Our Ref: 20/01016/HOU
Your Ref: 519 London Road,
Hilsea - 411...

LOCATION: 519 London Road, Hilsea, Portsmouth, PO2 9SA,

PROPOSAL: Construction of vehicle crossing **(20/01016/HOU)**

Drawing Title  
**Proposed Droob Kerb**

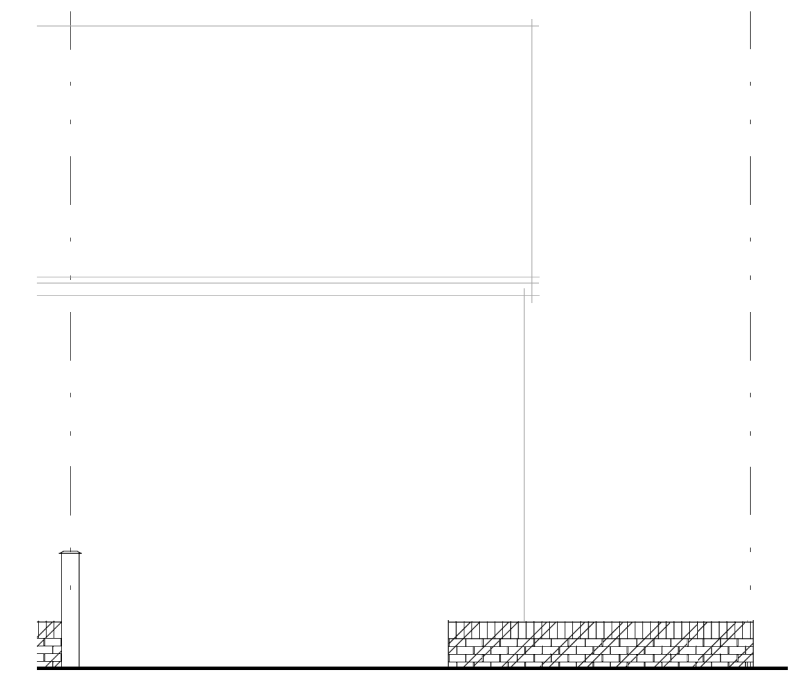
2) The block plan on the proposed plans does not measure correctly to the stated scale of 1:500. Please review and amend accordingly
